Re: **3308 4<sup>th</sup> Street Apartment Building**  
**3308 4<sup>th</sup> Street NW**  
**Traffic Circulation Layout**  
Engineer's Stamp 05-02-18 (H14-D109)

Based upon the information provided in your submittal received 05-04-18, the above referenced plan cannot be approved for Building Permit until the following comments are addressed:

3308 4th SREET, NW SITE PLAN FOR BUILDING PERMIT

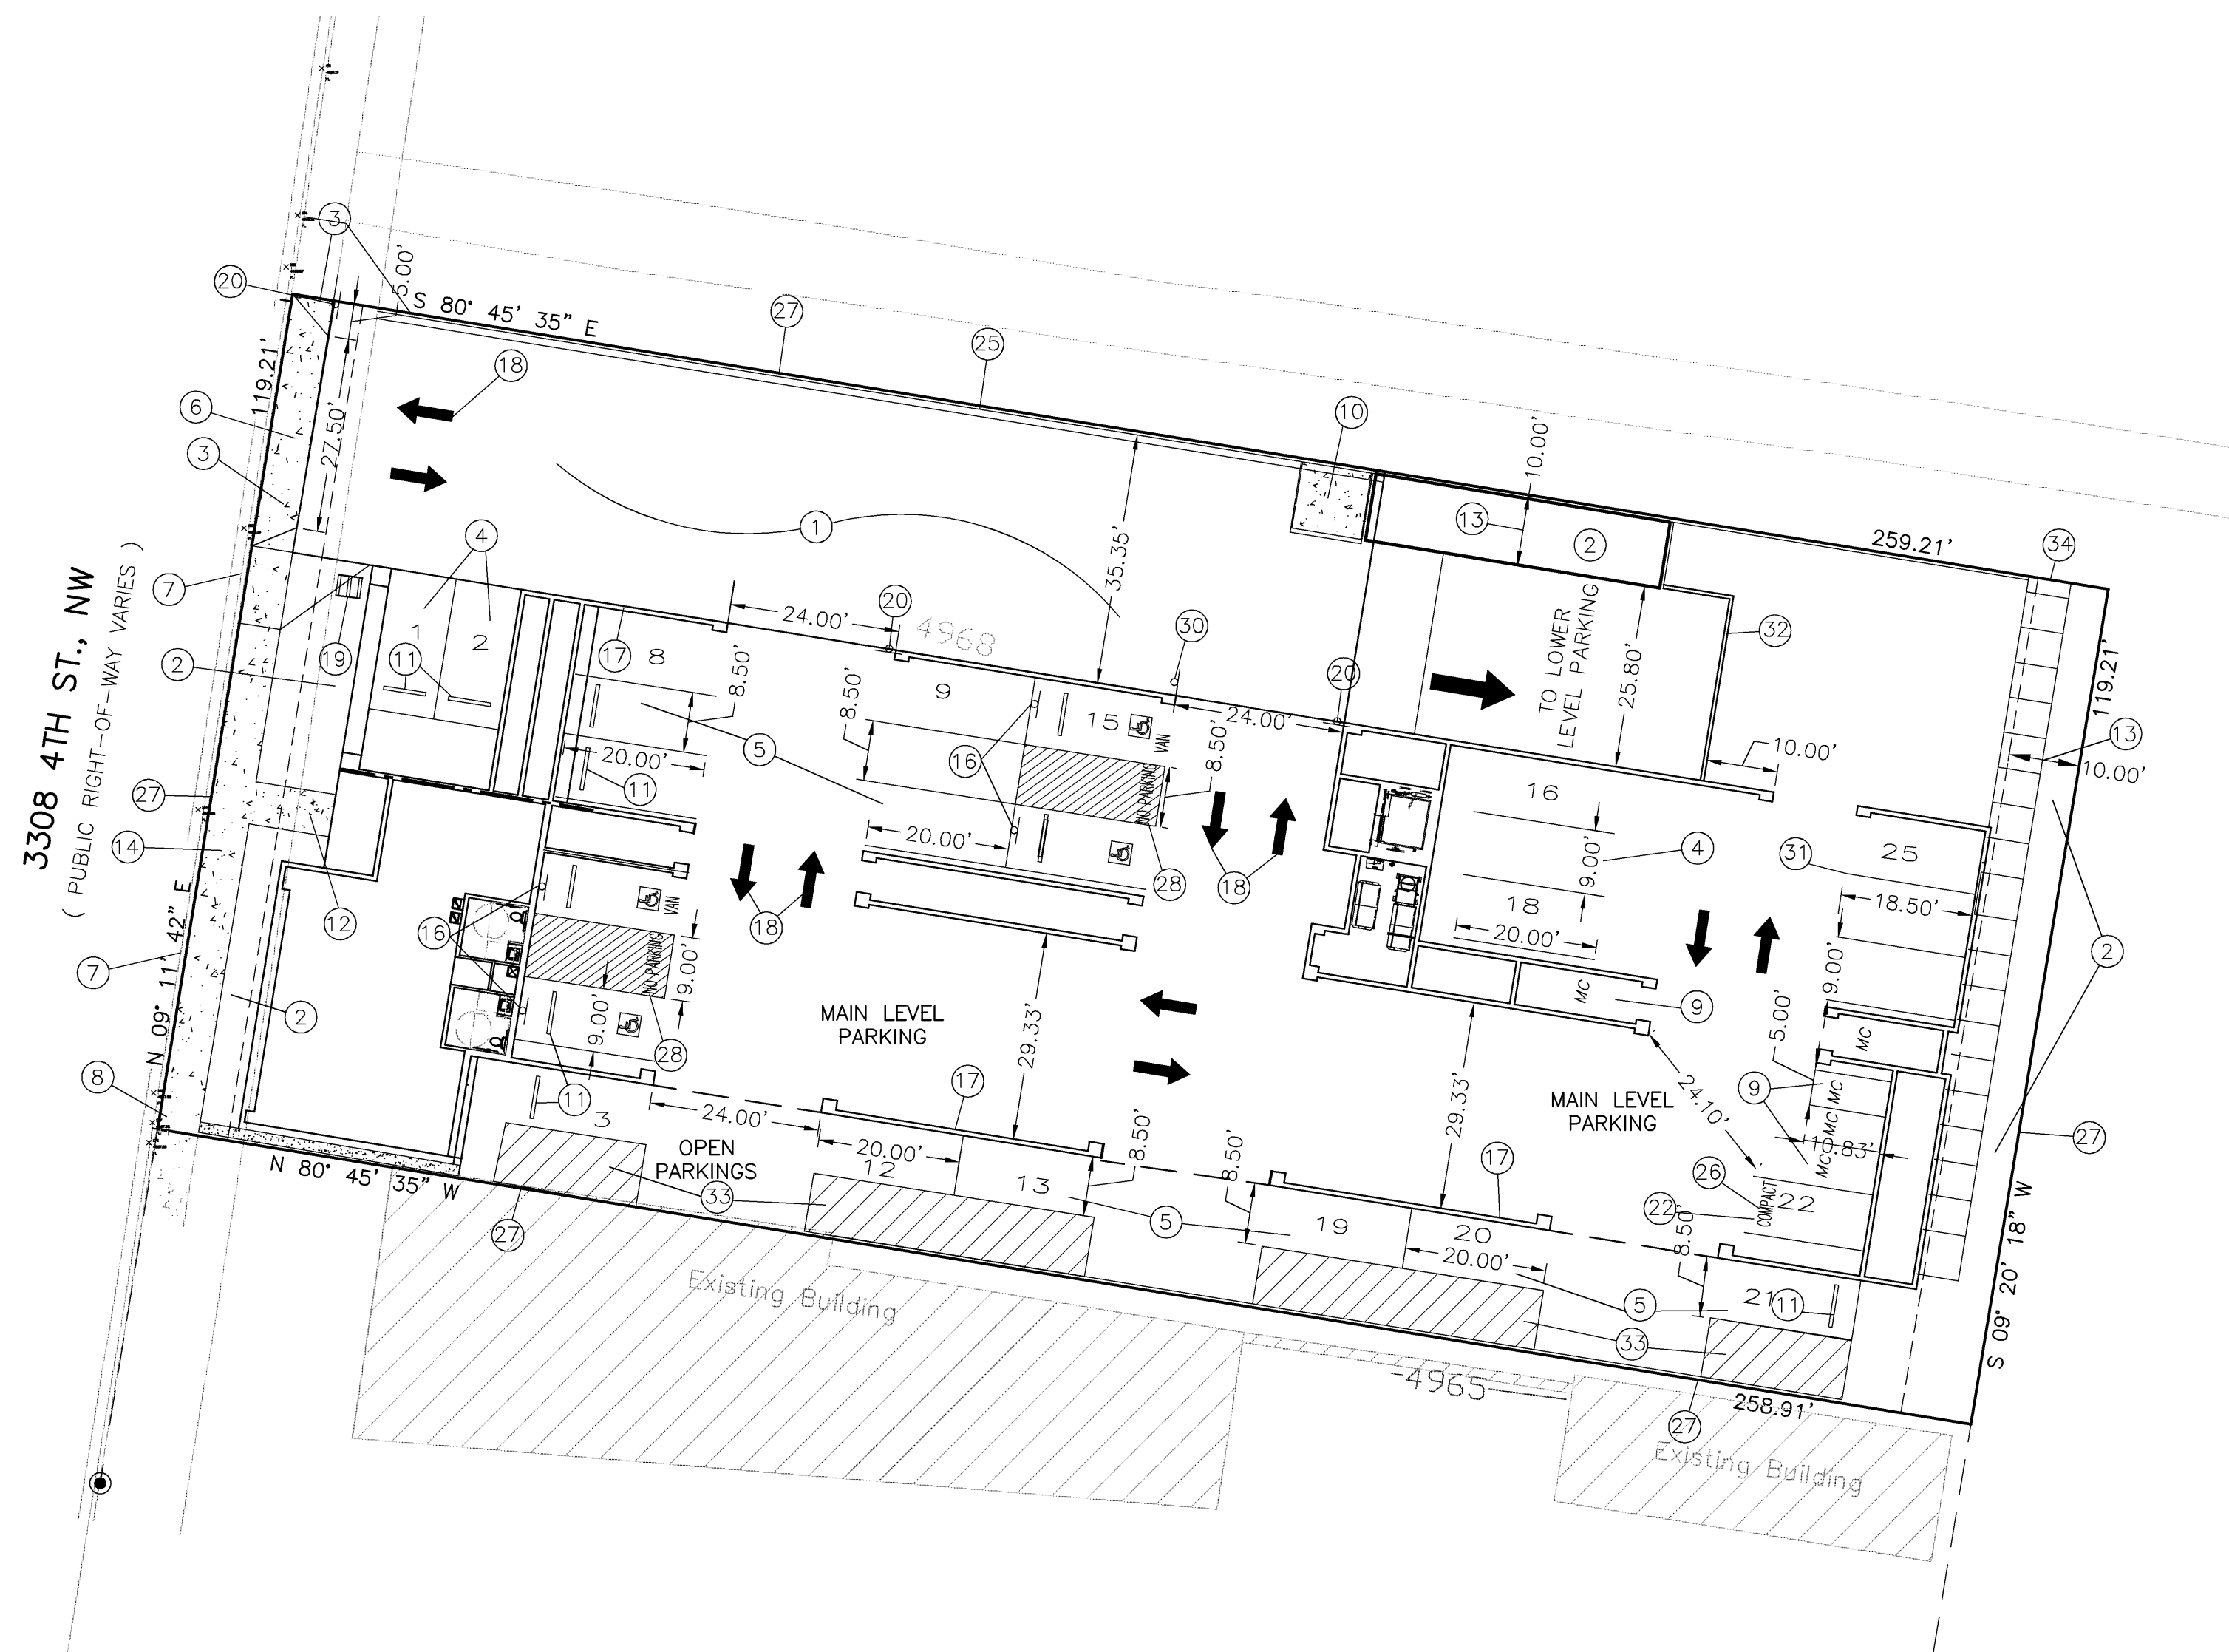
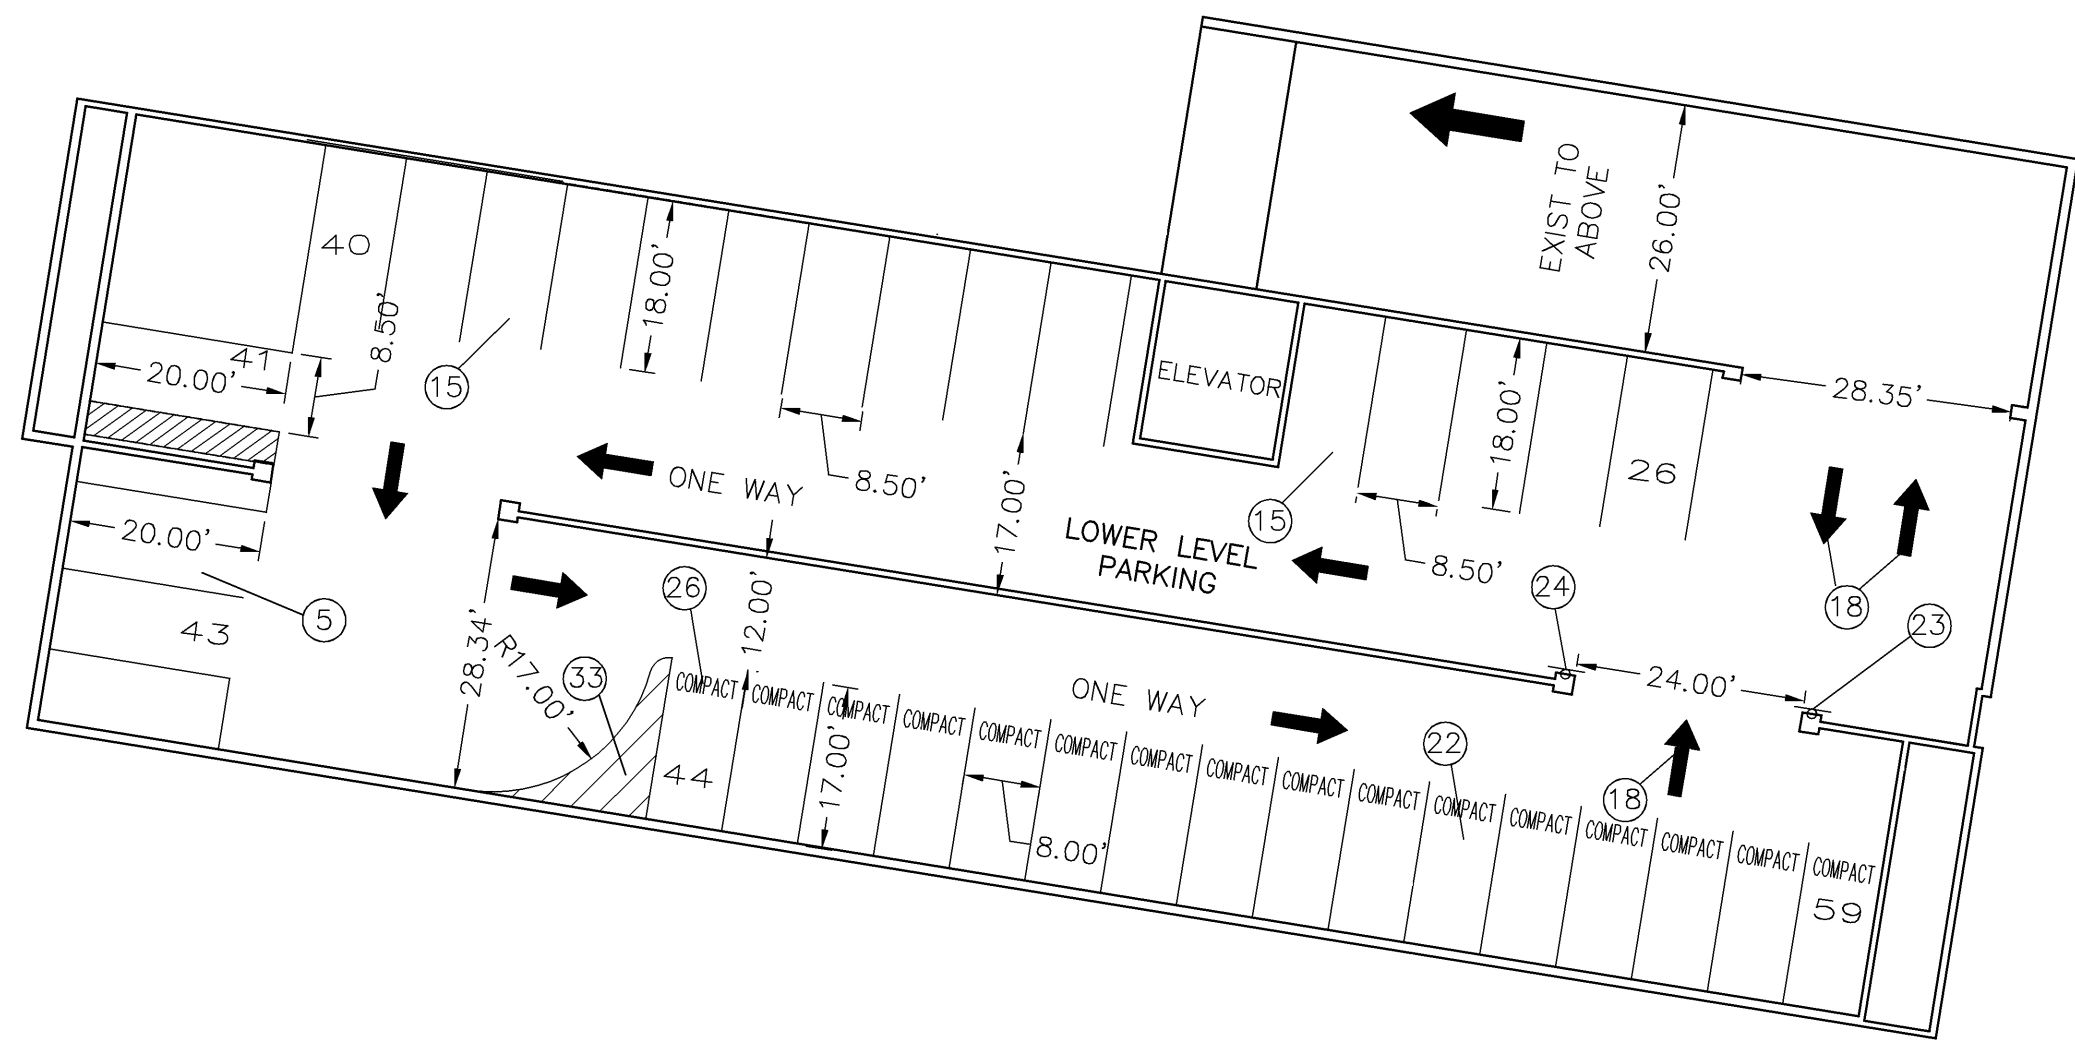
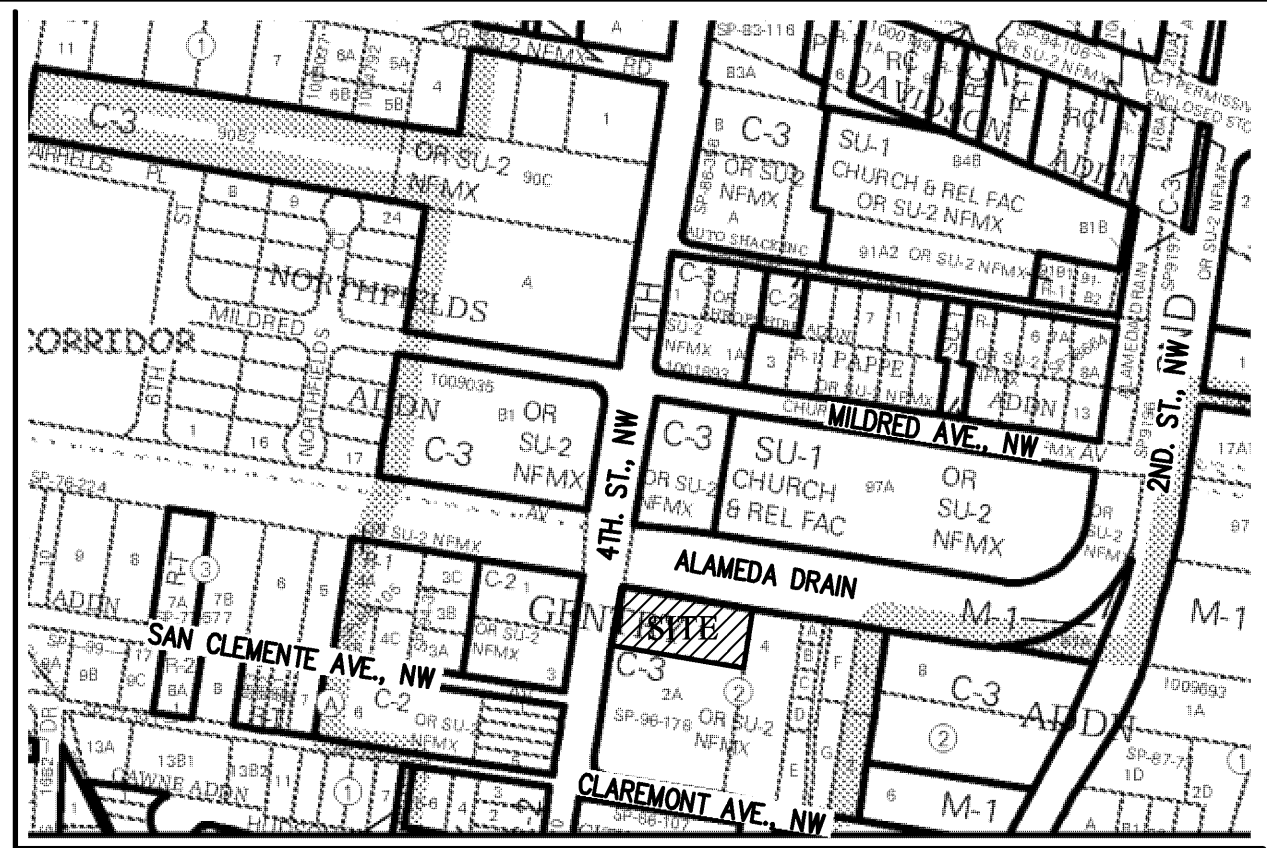
1. Either the two parking space at the front of the site or the pedestrian path may need to be moved. ADA accessible pedestrian pathway should not be placed behind parking space or adjacent to a vehicular way. Vehicle and pedestrian/wheel chair conflicts should be avoided as much as possible.

2. Clarify existing property lines and proposed property lines.
3. Label the compact parking spaces by placing the words "**COMPACT**" on the pavement of each space.

4. The ADA access aisles shall have the words "**NO PARKING**" in capital letters, each of which shall be at least one foot high and at least two inches wide, placed at the rear of the parking space so as to be close to where an adjacent vehicle's rear tire would be placed. (66-1-4.1.B NMSA 1978)

5. Please show turning templates for the design vehicle on the second floor. I am not sure cars will be able to make the turn.
6. The angle parking on the second floor is compact car size, please label the spaces compact. Please provide angles and dimensions.

7. Key Note 15 on the second floor should be 22.

8. Please dimension the openings to the open parking spaces.
9. A 5 ft. keyway is required for dead-end parking aisles. Parking spaces next to the neighbor's property need keyways.

10. Service vehicle and/or refuse vehicle maneuvering must be contained on-site; provide a copy of refuse approval.
11. One-way vehicular paths require pavement directional signage and a posted **"Do Not Enter"** sign at the point of egress. Please show detail and location of posted signs. A sign may be needed on the second level. I also have questions about the parking spaces below the ramp. Will there be an exit onto MRGCD property?

12. Please provide a sight distance exhibit, the exit next to the ramp going up the second level looks like it may have a sight distance issue.
13. Show the clear sight triangle and add the following note to the plan:  
"Landscaping and signage will not interfere with clear sight requirements. Therefore, signs, walls, trees, and shrubbery between 3 and 8 feet tall (as measured from the gutter pan) will not be acceptable in the clear sight triangle."
